KITTITAS COUNTY

MEMORANDUM

TO: All Staff
FROM: Justin Turnbull, County Surveyor 
DATE: January 12, 2022
SUBJECT: County Survey Review of BL-21-00029 Pratt

RECORD OF SURVEY

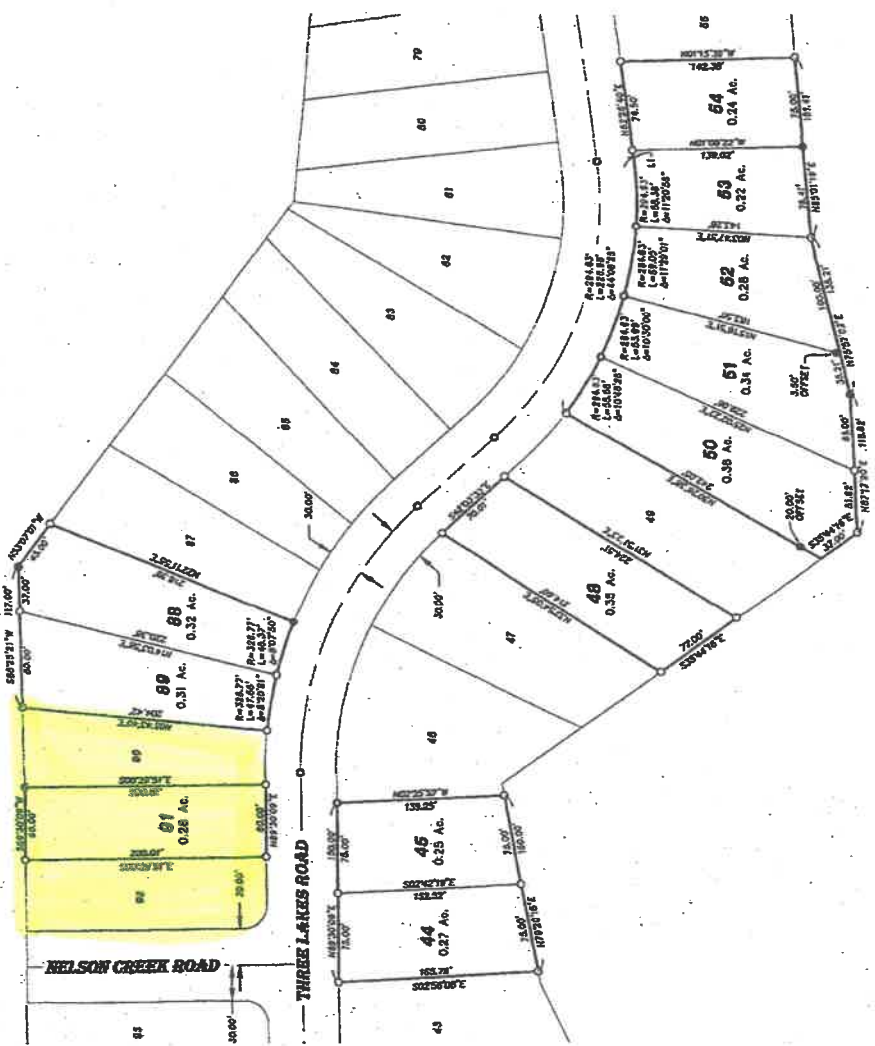
1. No lot closures were provided
2. Page layout needs to meet requirements per RCW 58.09.050 (1)(a))
3. Name of surveyor is missing
4. Survey equipment and procedures are missing. (Note identifies that map is not based on an actual field survey.)
5. Section, Township and Range need to be shown at top of page per WAC 332-130-050(1)(iv)(A))
6. Ties to adjoining survey of record are not identified per RCW 58.09.060(1)(c))
7. Proposed lots should be labeled with Lot Number and area
8. New division line should be surveyed and staked in the field and the outside perimeter of the parcel shall be delineated on the face of the map.
9. All roadways must show underlying ownership (Private/County/State), easement or right of way and surfacing material
10. Roadways must show centerline with bearings and distances.
